SNPA ExQ1 Responses

Question 17.5 – SNPA and NRW raise concerns around under-reporting of significant effects. Please identify specifically where your concerns lie, with supporting reasons for this

Question 17.6 – SNPA’s RR makes reference to visual impacts from specific points within the National Park, such as from Carnedd Llywelyn and the Carneddau as a whole. Noting that VP10 is from Carnedd Llywelyn and VP is from Foel Fras;

FIGURE TITLE:
Viewpoint 10 - Carnedd Llewelyn

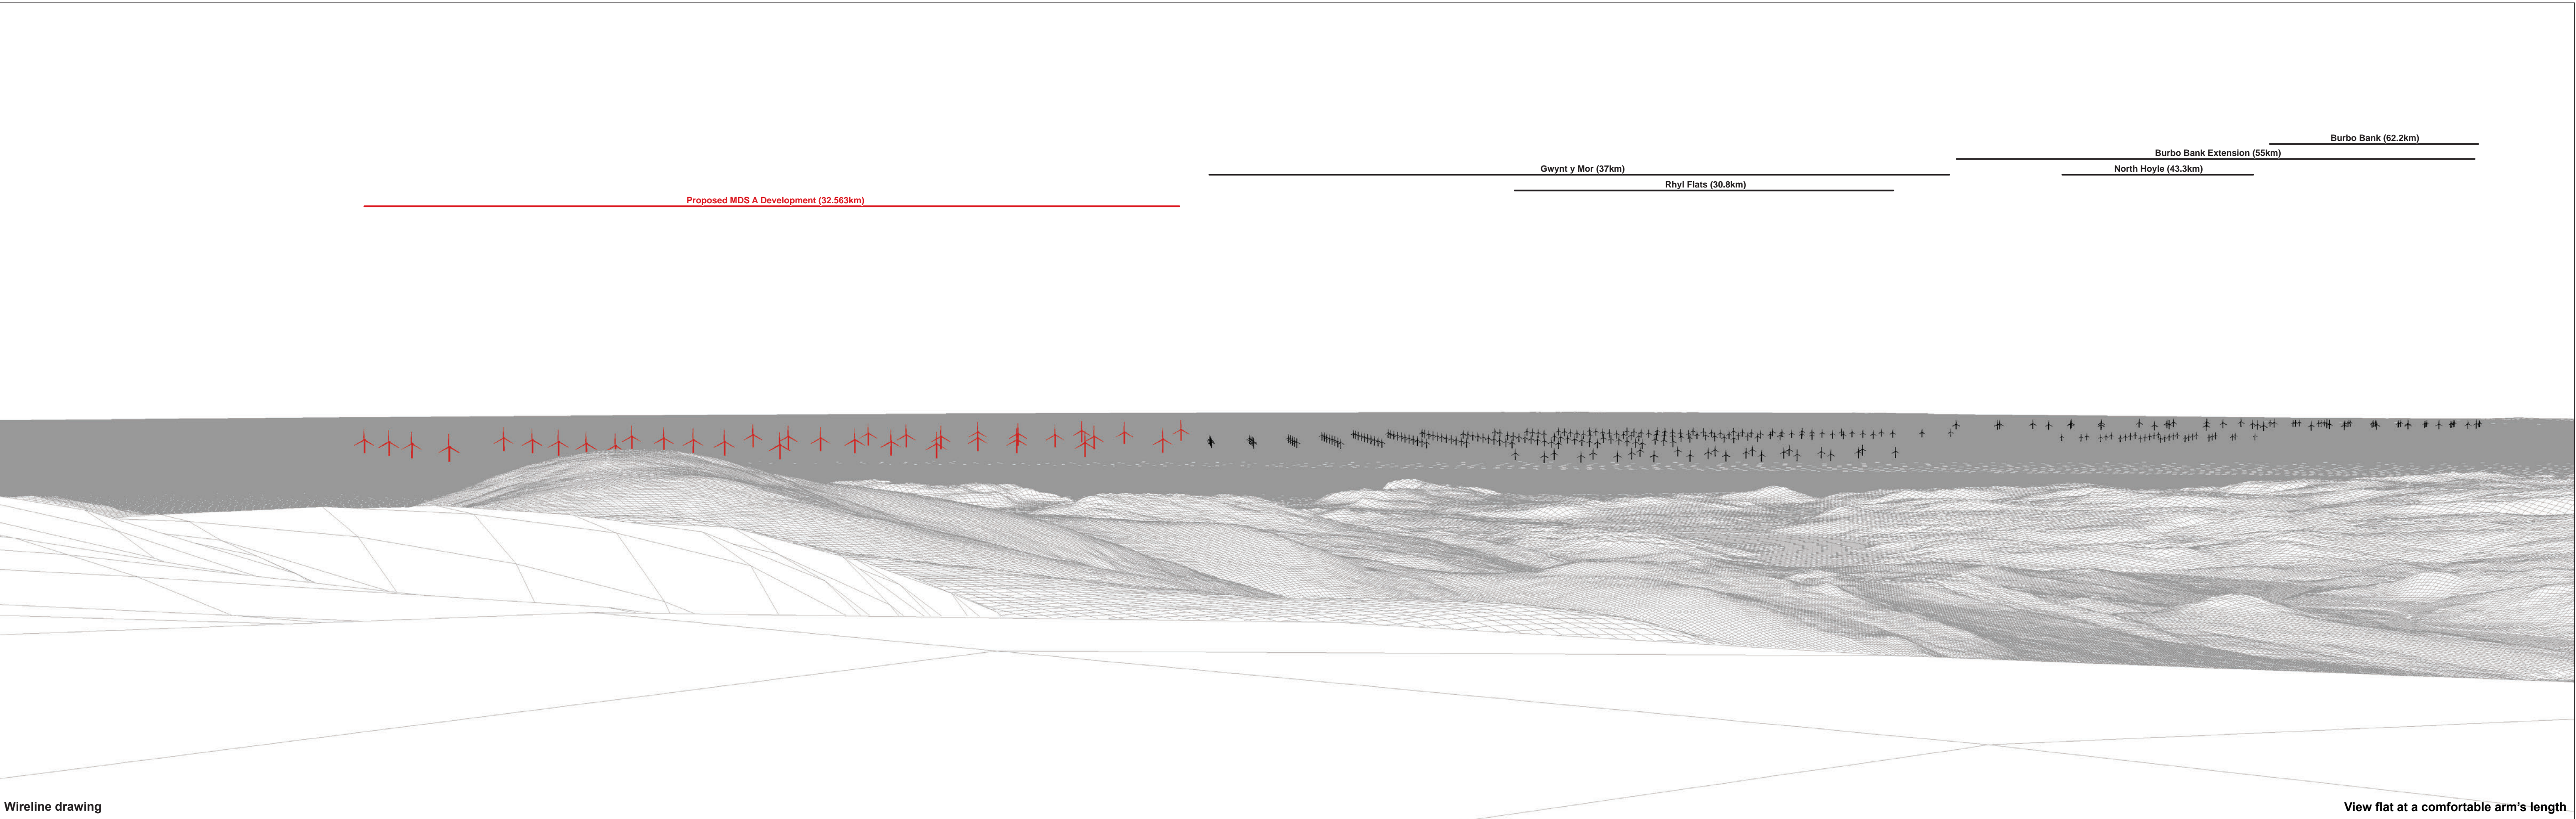
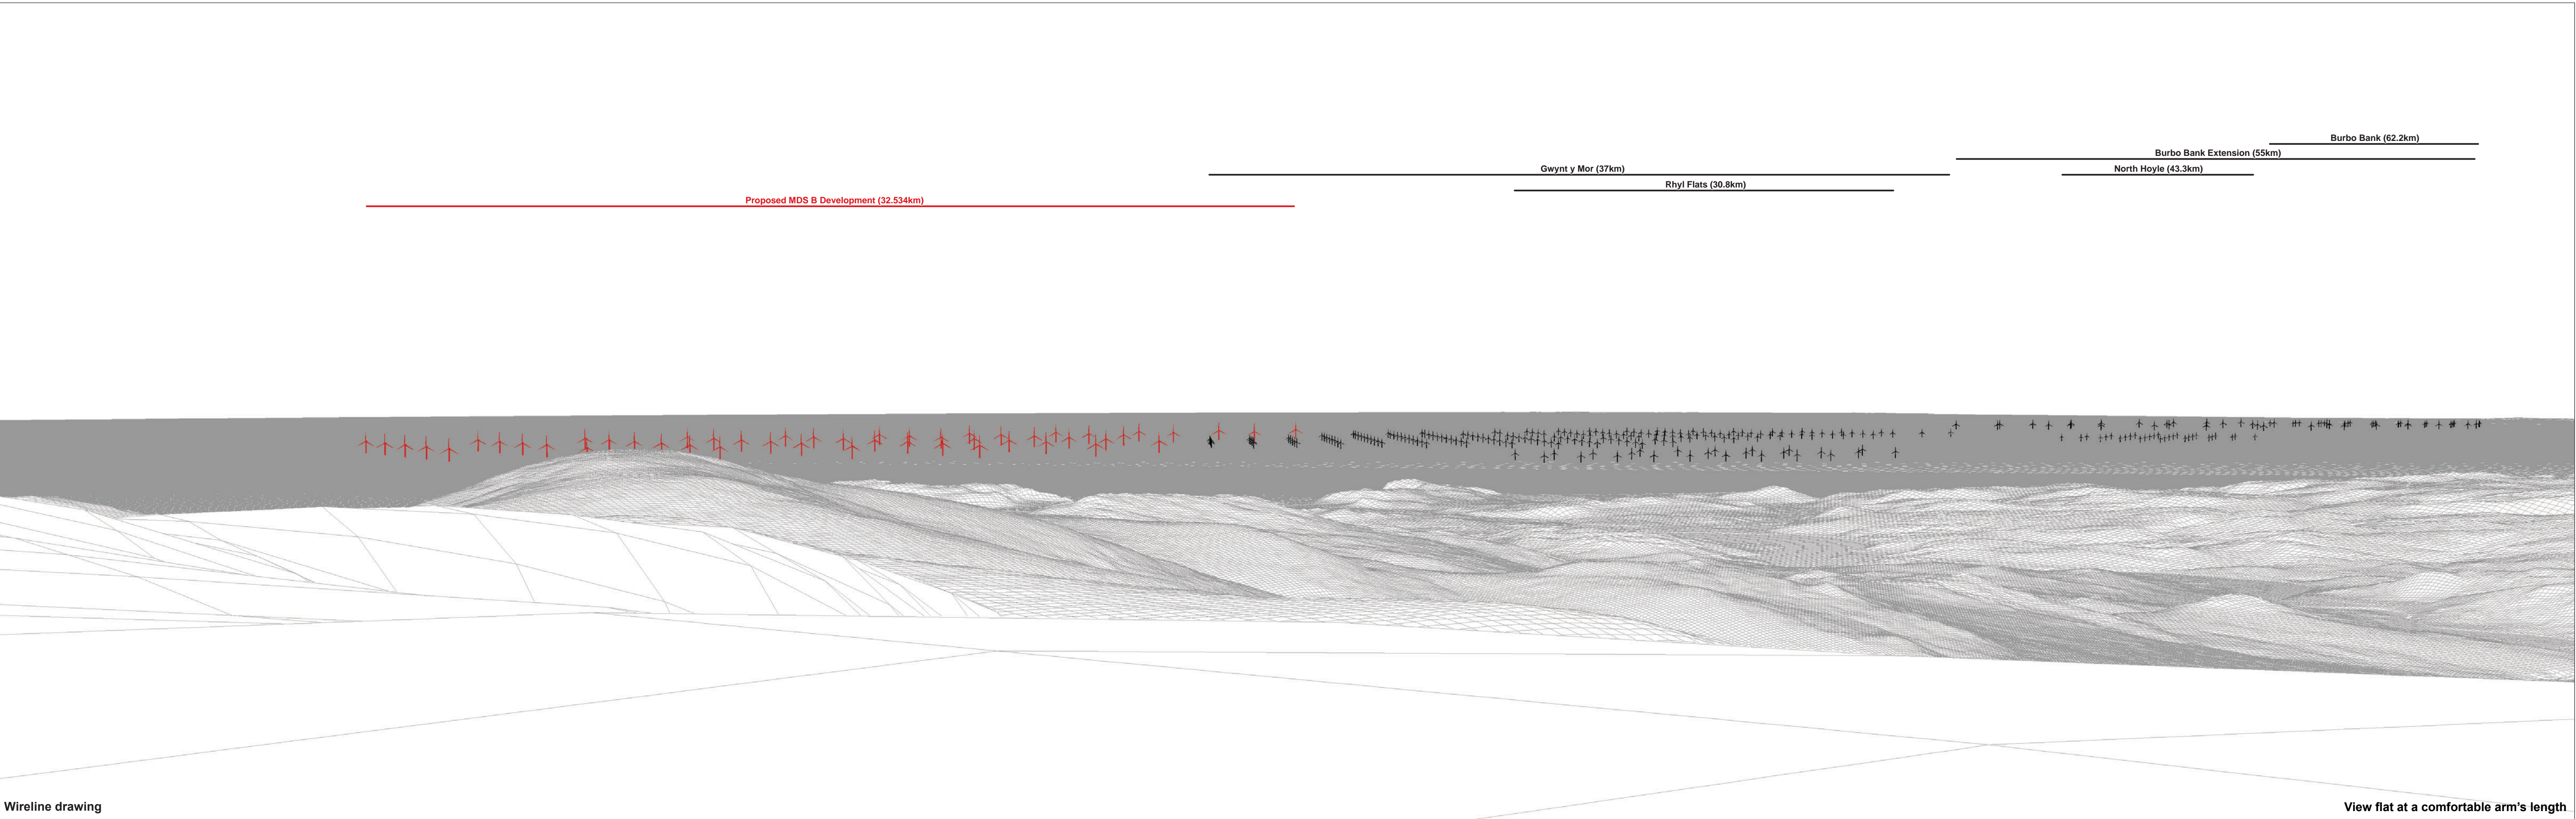
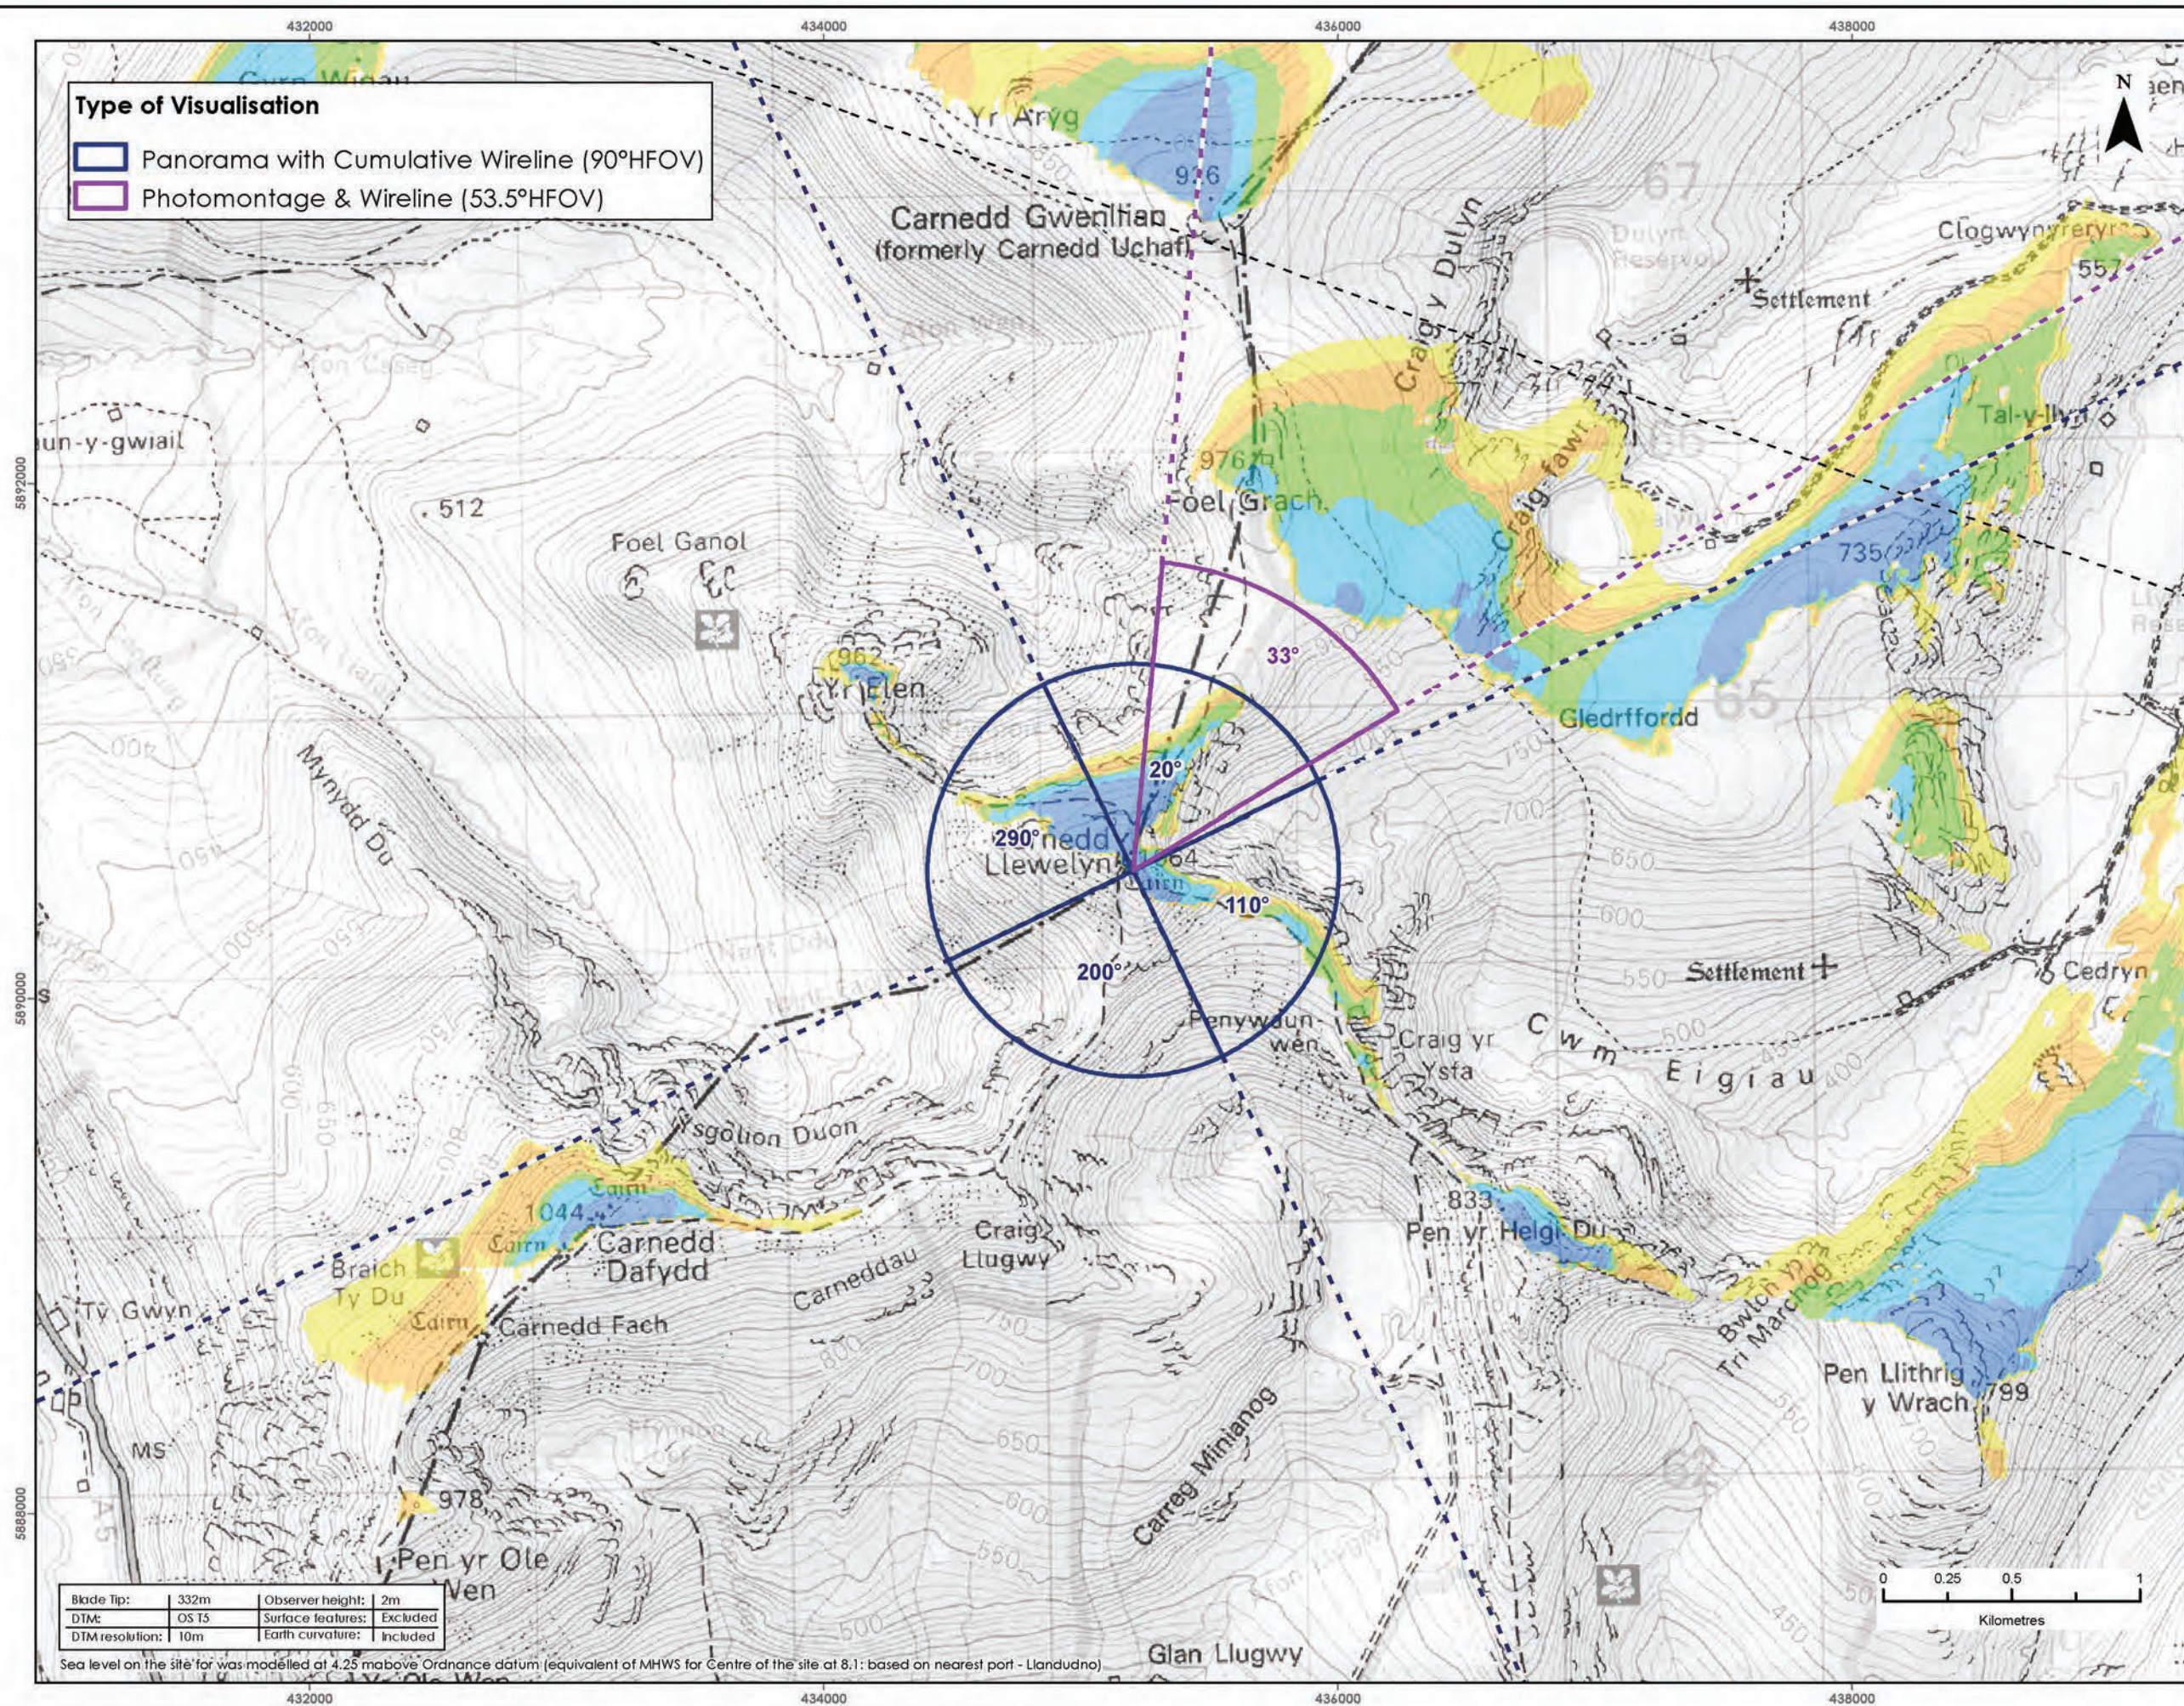
- The PEIR found significant effects at four of these, while we queried the finding of non-significant at VP36 Tal-y-Fan. Effects on the closer viewpoints 12 and 40 are recorded as major- moderate in the ES, with the more distant viewpoints 10 and 38 being moderate. A moderate-minor and non-significant effect is recorded at VP34 Snowdon Summit. The assessment for VP36 Tal-y-Fan is stated to be moderate but not significant. We suggest that, although close to the borderline, this should be identified as significant. We note that effects at VP38 Foel-fras are moderate (significant), on a very similar but more distant view. We highlight an inconsistency in the sensitivity assessment for VP36 that may account for this

- a) **Is SNPA satisfied that these viewpoints are representative of this part of the National Park (ie the Carneddau);** Yes
- b) **Does SNPA agree with the Applicant's assessment that residual effects from these viewpoints would be moderate adverse and significant;**
Agree that these viewpoints in particular would be moderate (significant). As per the findings of the LUC review however we believe that Tal y Fan should also be significant
- c) **Does SNPA agree with the Applicant's assessment that residual effects on the SNPA Landscape Character Area (LCA) 02; Carneddau Range would be minor moderate adverse and not significant?** In terms of the area/LCA as a whole, yes. Specific viewpoints (ie Carnedd Llywelyn) within the LCA would be 'significant' however (as the authors note).
